**Consultation Response from KC,
Trees****2023/91483 adj, 33a, Church Lane, Clayton West, Huddersfield, HD8 9LY****Demolition of garage and erection of detached dwelling****Date Responded: 06/02/2024****Responding Officer: D. Atkinson****Responding Ref: 87/91**

Client ACUMEN		
Project ERECTION OF PROPOSED DWELLING AT 33A CHURCH LANE, CLAYTON WEST		
Project No 2844	Drawing No (100)02	Rev A
Description PROPOSED SITE PLAN

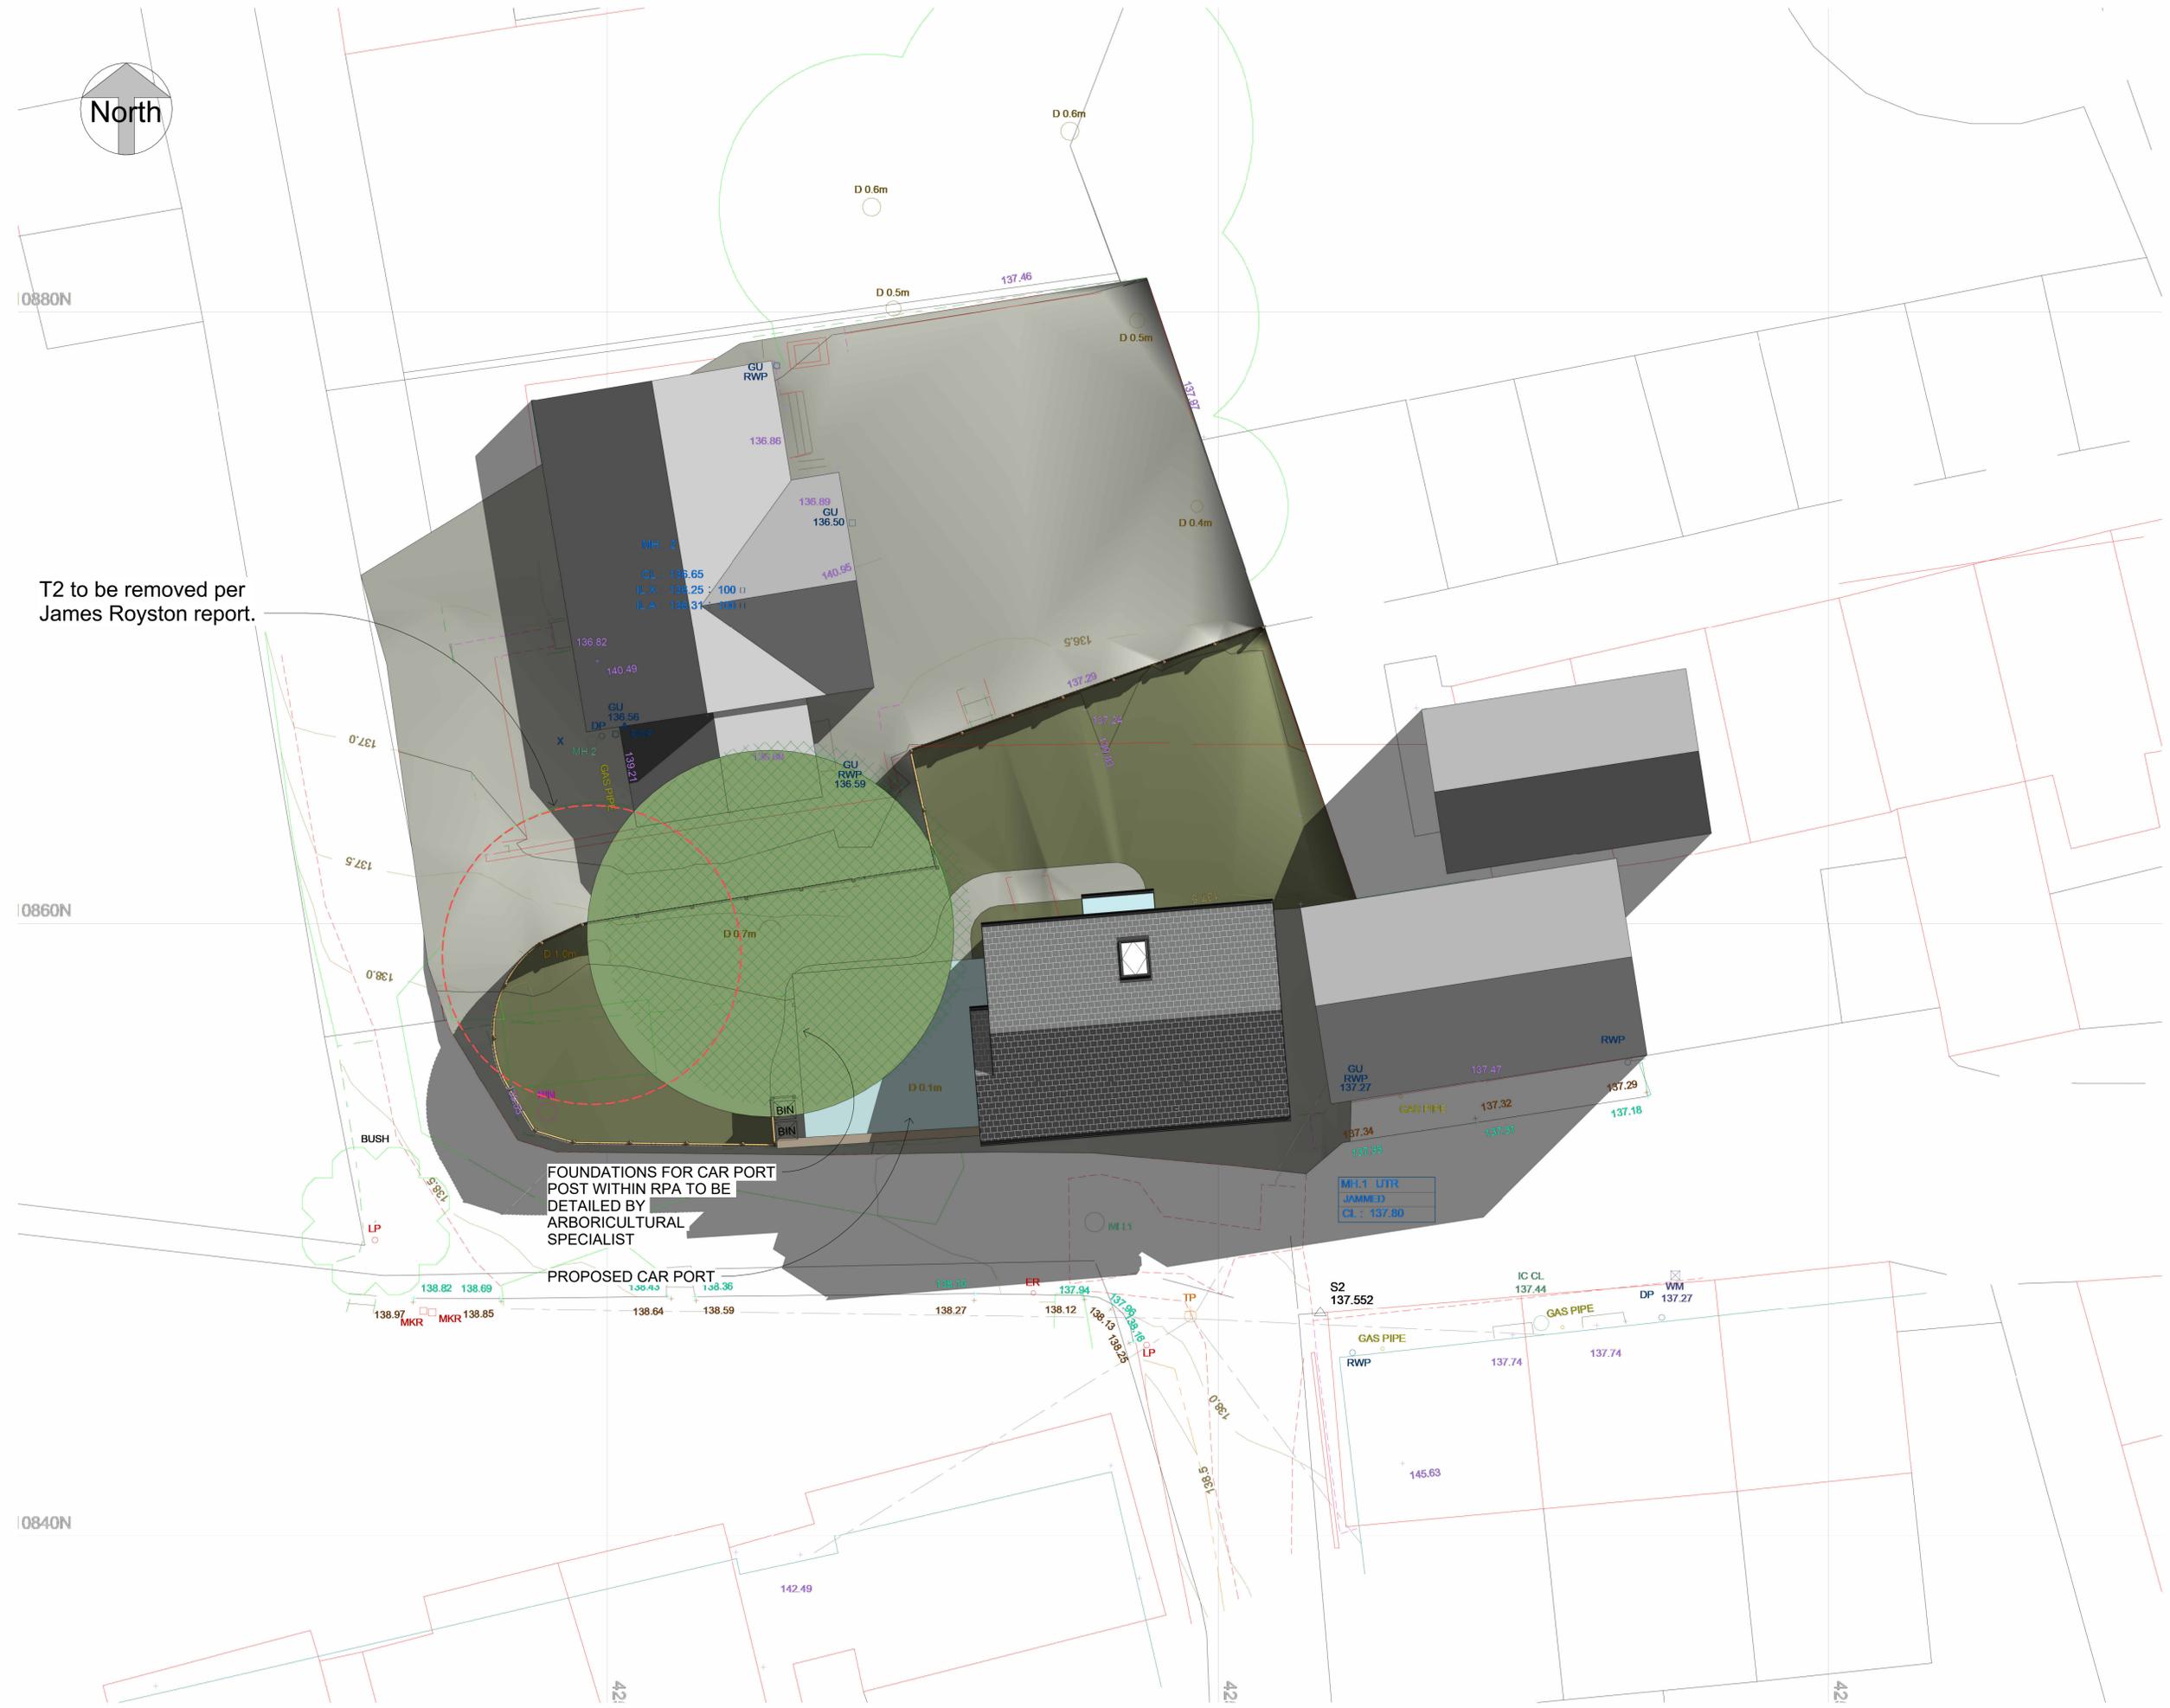
The recommendation at the TS stage was to remove T2, but there is no explanation for the change.

For this development the proposed parking for the new dwelling will be under the of the Lime (T1). It will also restrict the parking of the current dwelling (33a) to being under the Lime tree and Horse Chestnut. Lime trees can drop a large amount (perceived or otherwise) of debris (i.e. twigs, epicormic growth and dead wood of various sizes).

PROPOSED SITE PLAN

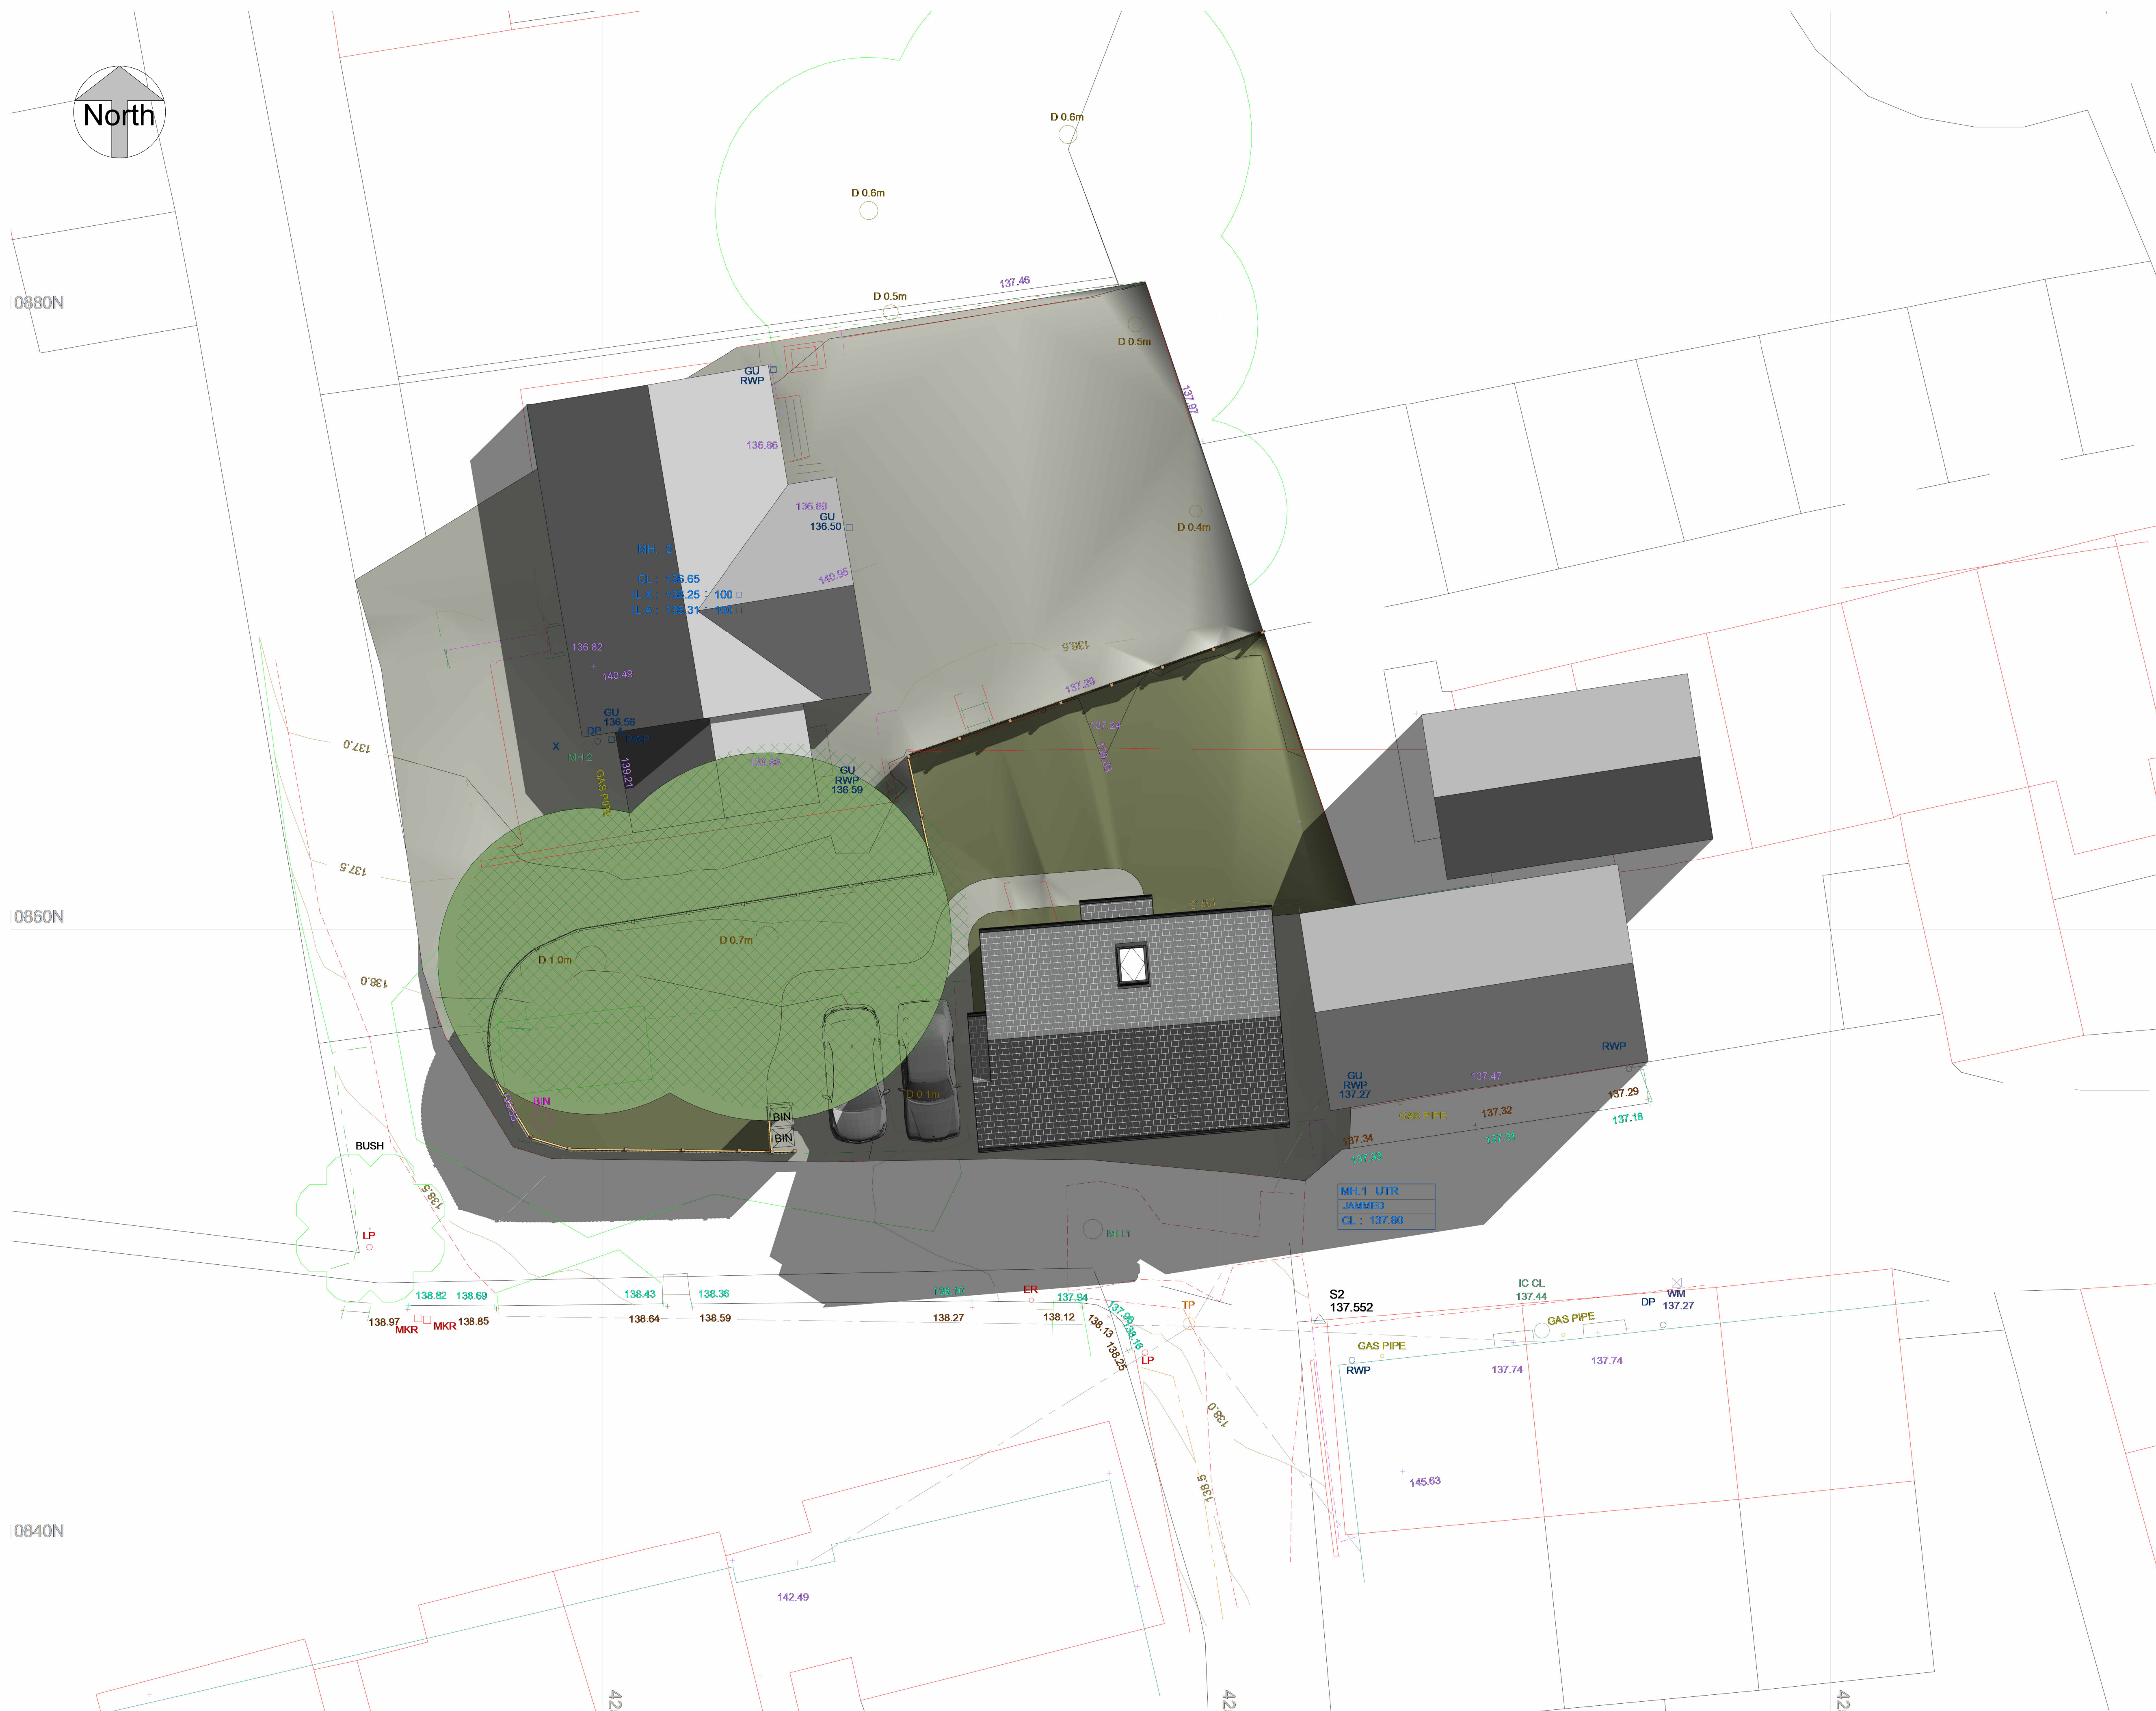
The Arboriculture Impact Assessment (AIA) submitted for the application Ref: 230329 AIA doesn't include the Tree Survey (TS) on which it is based Ref: 230329/TS. There also appears to be change in the valuation/condition assessment of the trees between the AIA and the TS. T2 has changed from Category U in the TS to being retained within the AIA.

The current property could foreseeably notice the issues above when cars are parked under the canopies. However, the existing garage, and a section of driveway aren't under the canopies of the trees, so the car/s could be parked in the garage protected or at least in a less impacted zone. This gives the current residents a choice, which the future residents will not.

Overall, there is an objection to the proposal from a KC Trees perspective. KC trees are not convinced that the AIA has given due consideration to the proposed end use of the space adjacent to retained trees and it is considered that this would place additional pressure on the trees for the reasons mentioned above and the proposal conflicts with adopted KC Local Plan Policy LP24 (i) and LP33.
